**WEST SUSSEX COUNTY COUNCIL
STRATEGIC PLANNING CONSULTATION**

SUBJECT: LU/208/11- Alterations to front/side garden to form driveway, incl. crossover onto Lyminster road for vehicular access.

Forge Cottage, Lyminster Road, Littlehampton, West Sussex, BN17 7PS

SITE PLAN 1:100

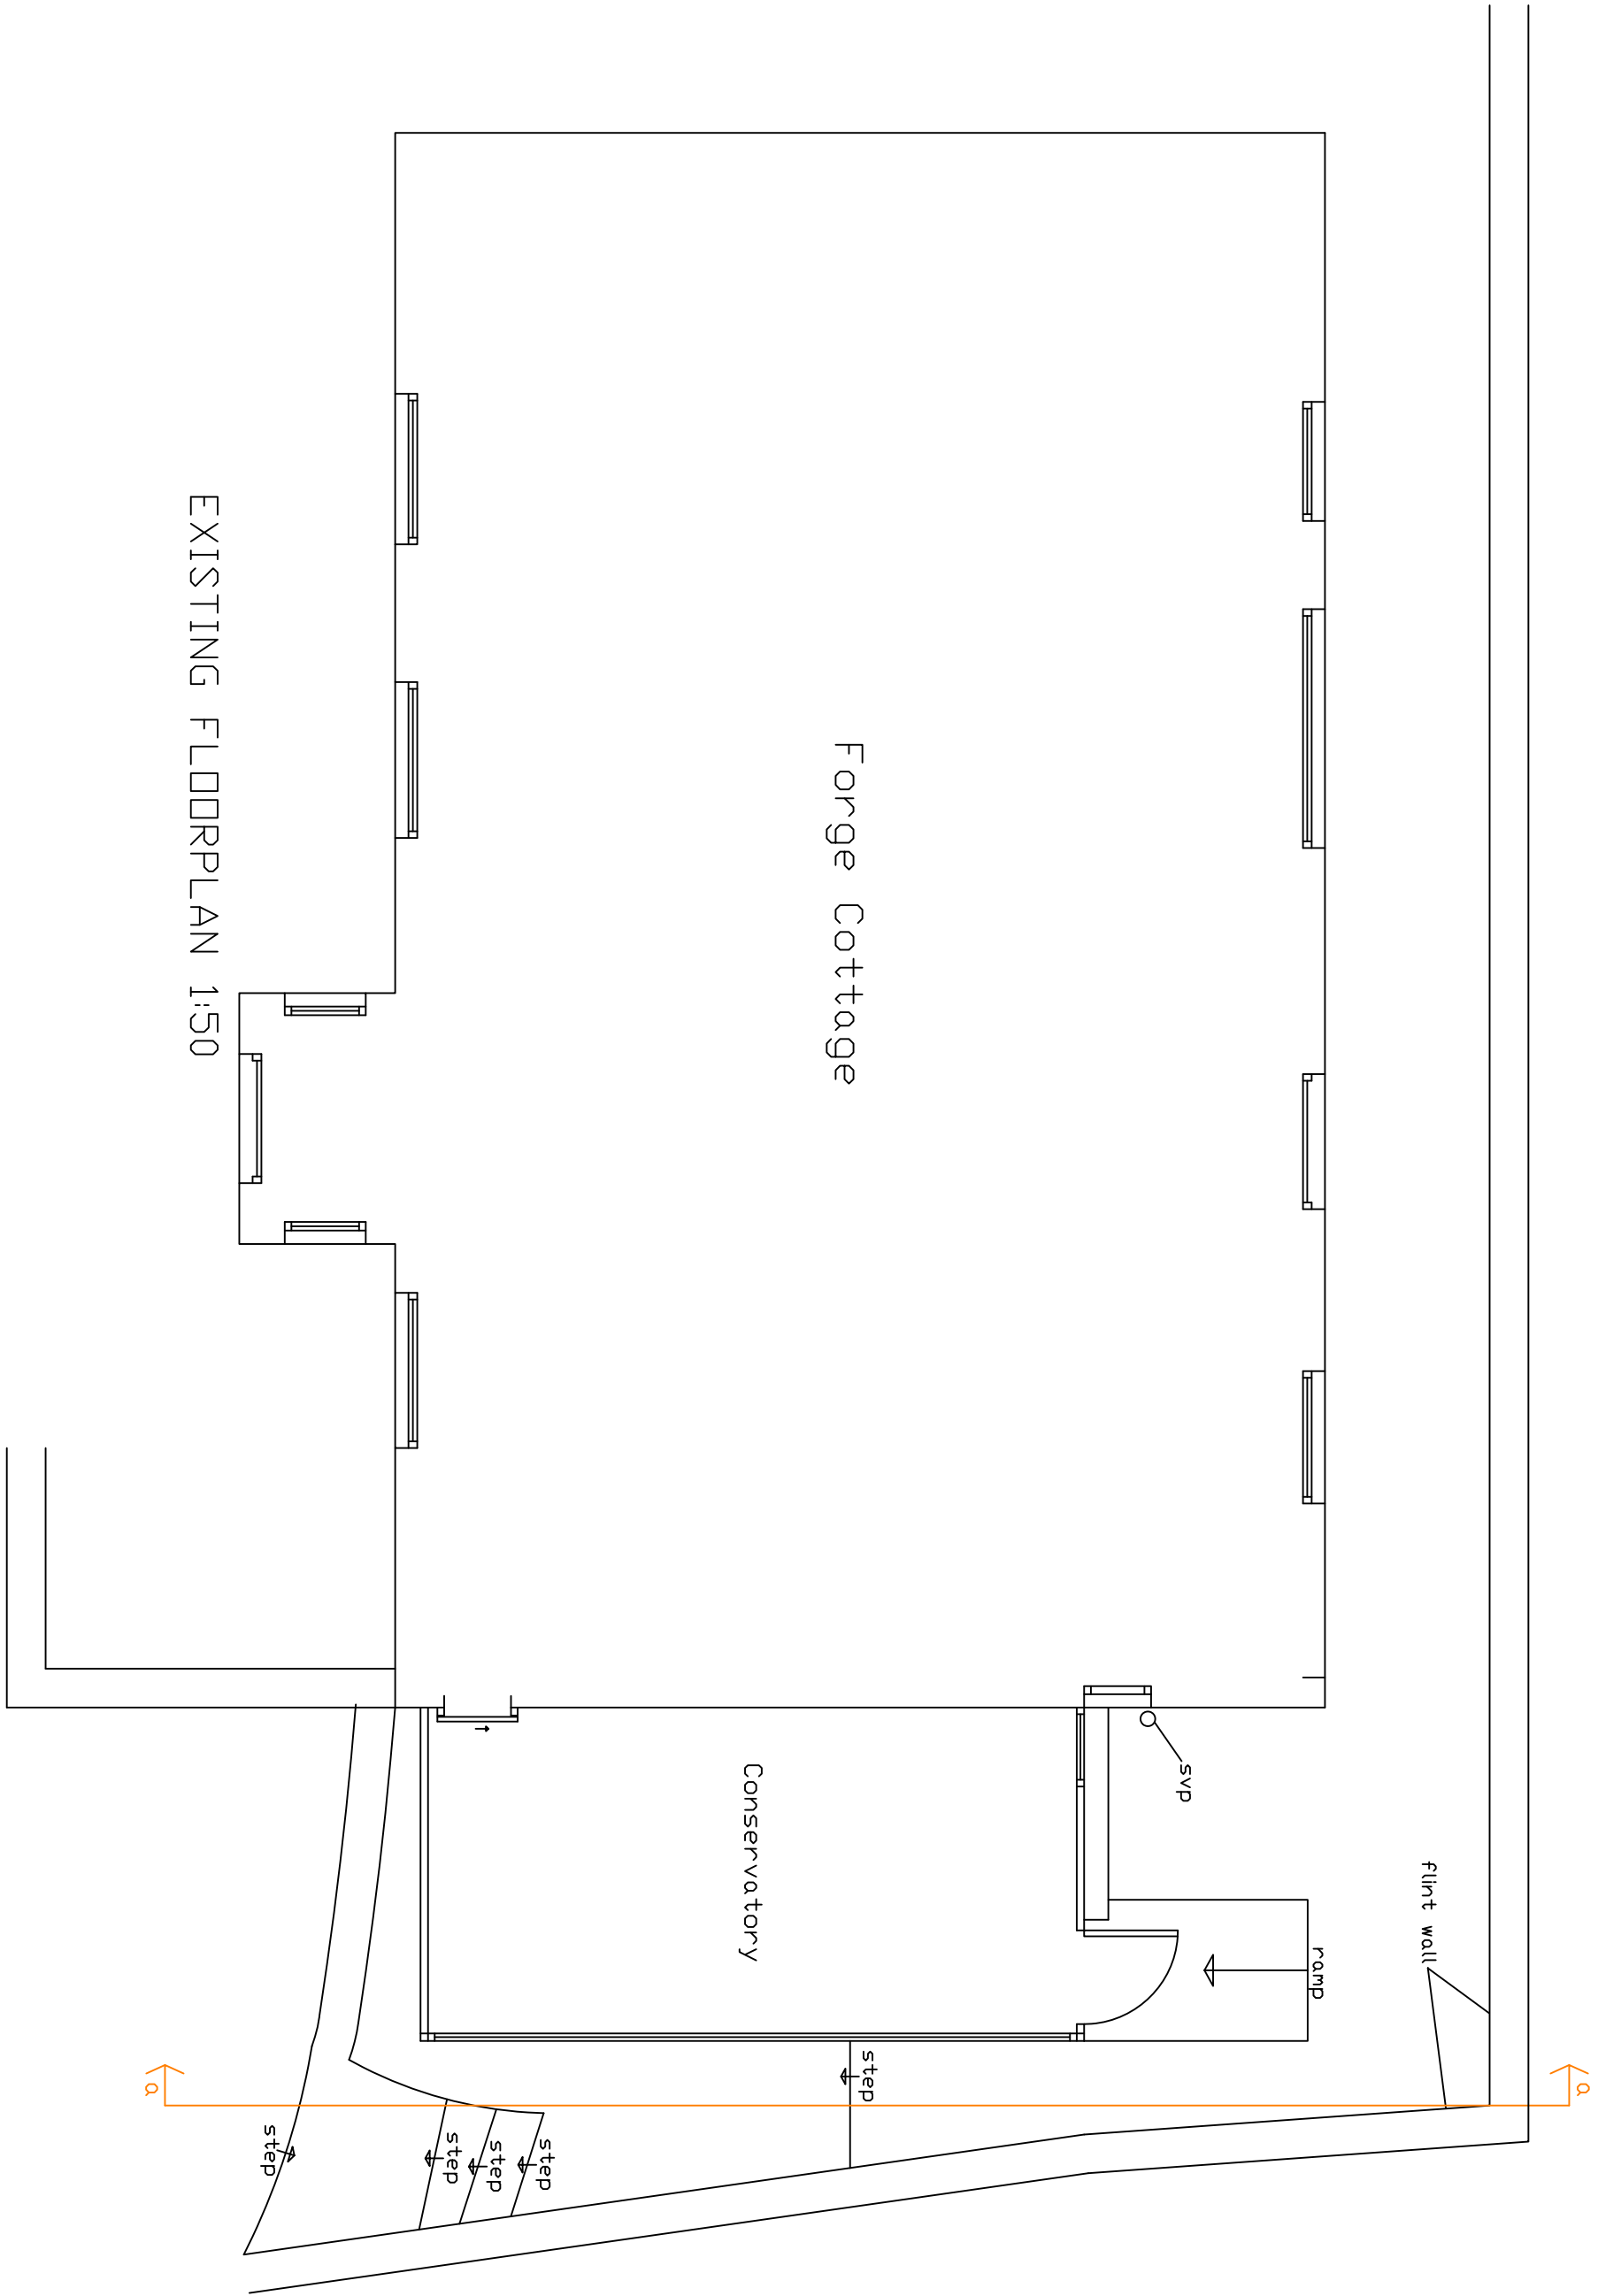
The proposal is as described above. Visibility from the point of access is acceptable but could be further improved by pruning the hedge to the south of the site, which falls within the applicant's control. In addition the applicant will need to demonstrate that adequate vehicular visibility splays can be achieved onto Lyminster Road (A284), these splays should be in accordance with the guidance set out in Manual for Streets.

It is also noted that there are to be two parking spaces within the site. On the plans viewed via ADC's website there is no way of telling where the cars will be parked within the site and if a turn on site facility is available. Given the high volume of traffic using the A284 a turn on site facility would be required.
